Application No: P/171/21/DOC
Site Address: Rear of Inglenook Hotel 253-255 Pagham Road Pagham PO21 3QB
Description of works: Approval of details reserved by condition imposed under ref W/4001476 (P/58/19/PL) relating to Condition Nos 10 - proposed location of one fire hydrant or stored water supply, 12 - soft & hard landscaping, 14 - materials & finishes and 15 - boundary treatments.

Thank you for your internet representation made on 24th December 2021 which has been recorded as an objection with the comments as follows:

INGLENOOK PROPOSED FIRE MAIN SKETCH

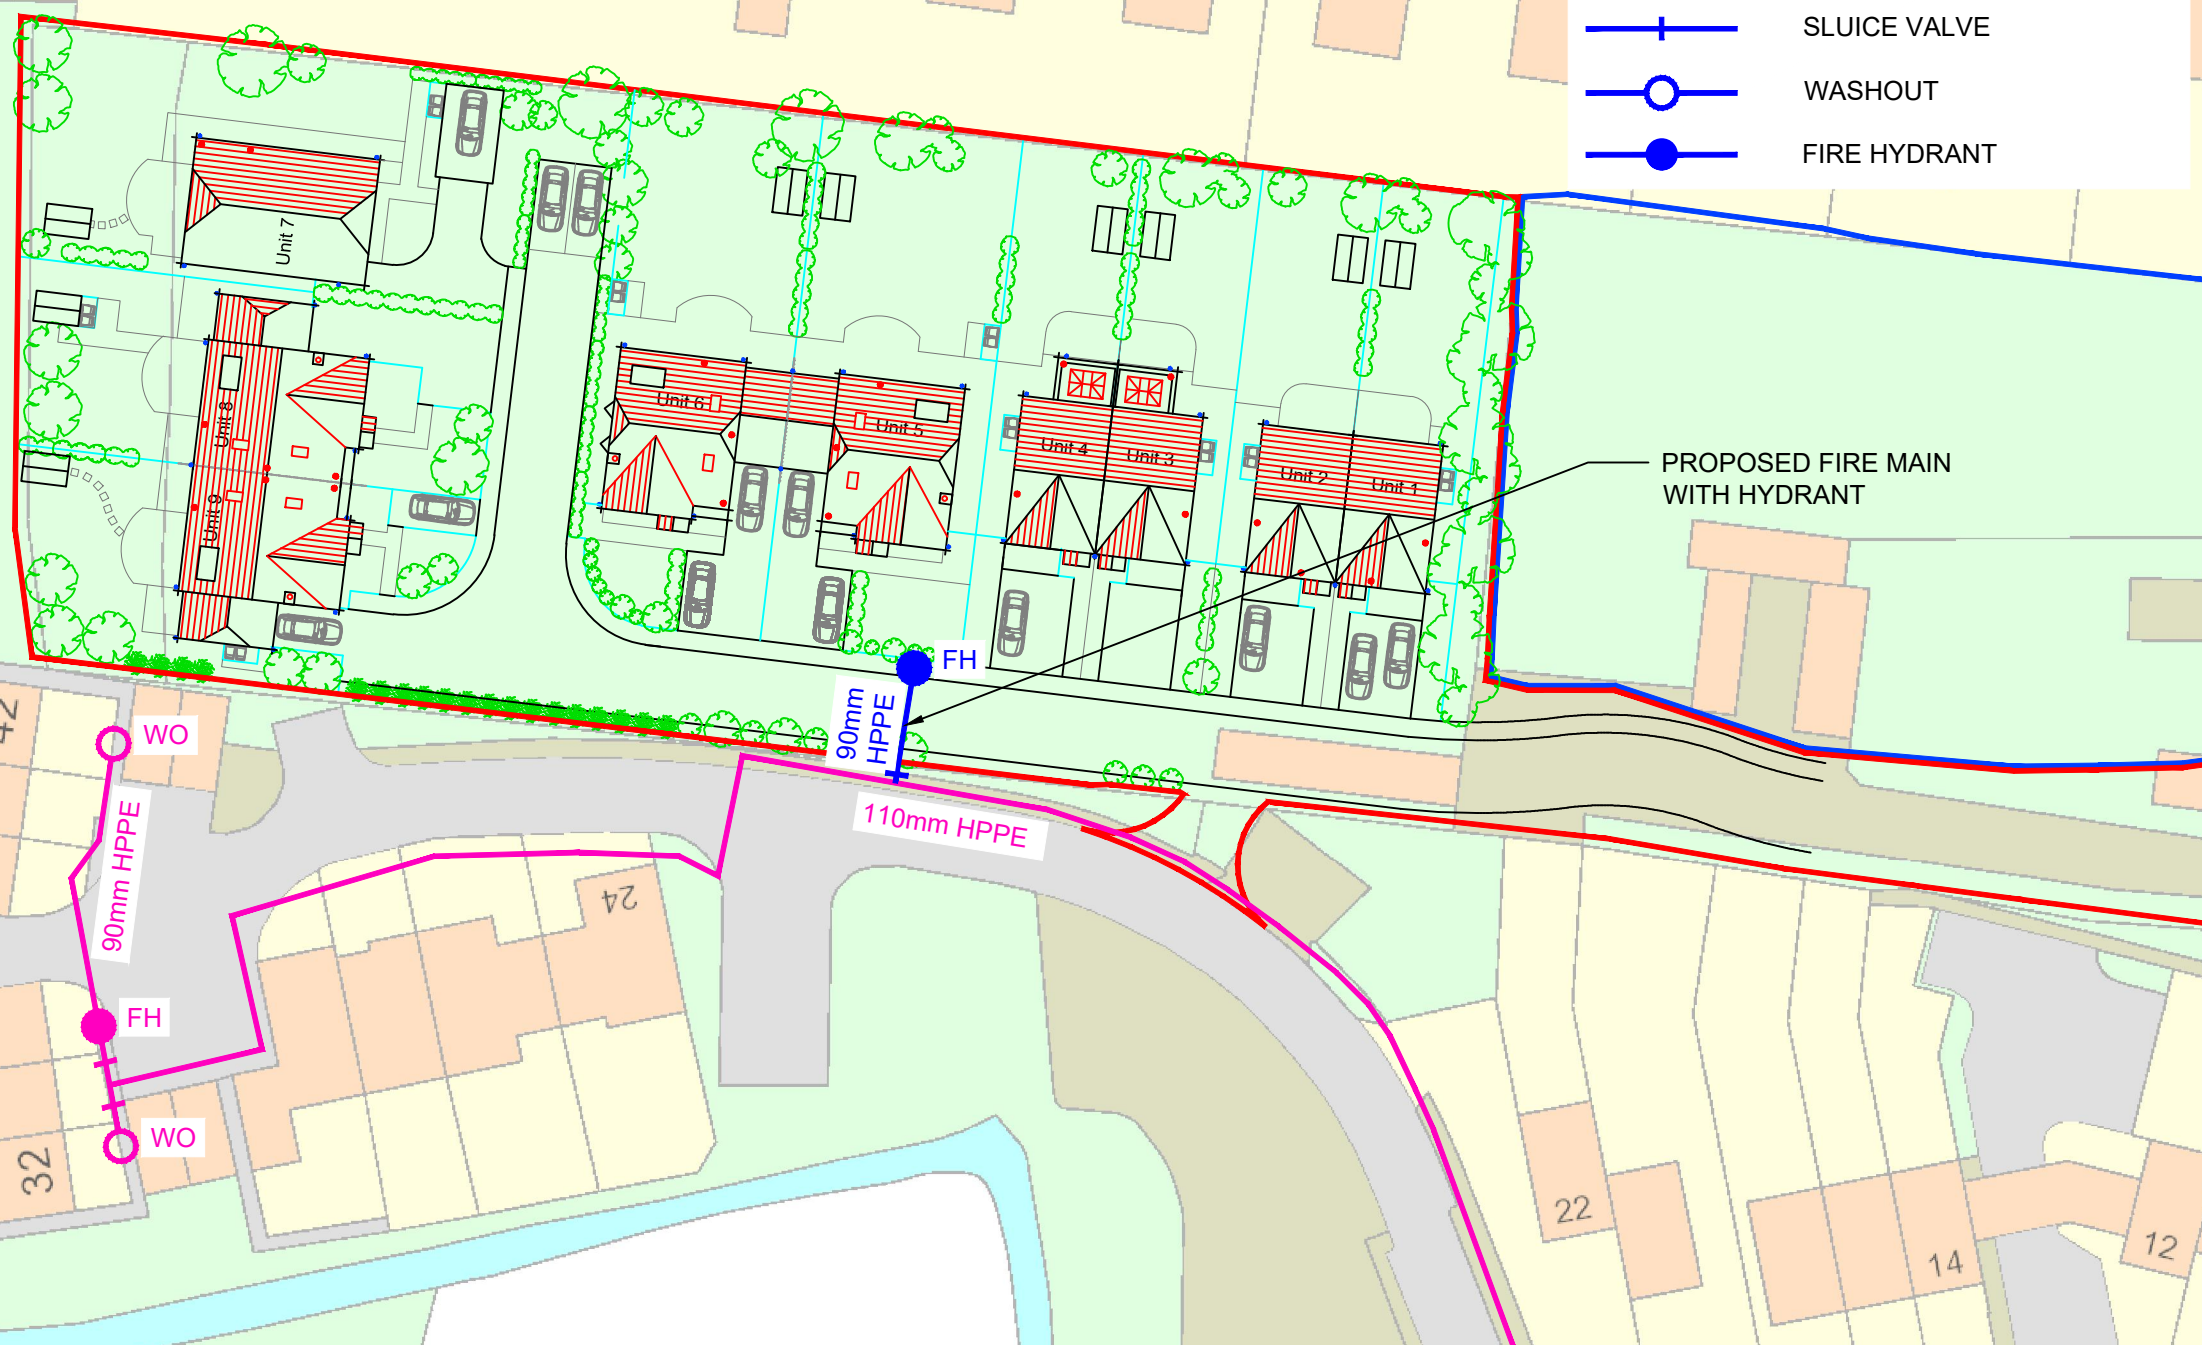
This application should be rejected on the grounds that the diagrammatic plans for the fire hydrant and landscaping are presented with site boundaries which are inaccurate. The boundary as shown has not been approved and deviates from the original and approved application.
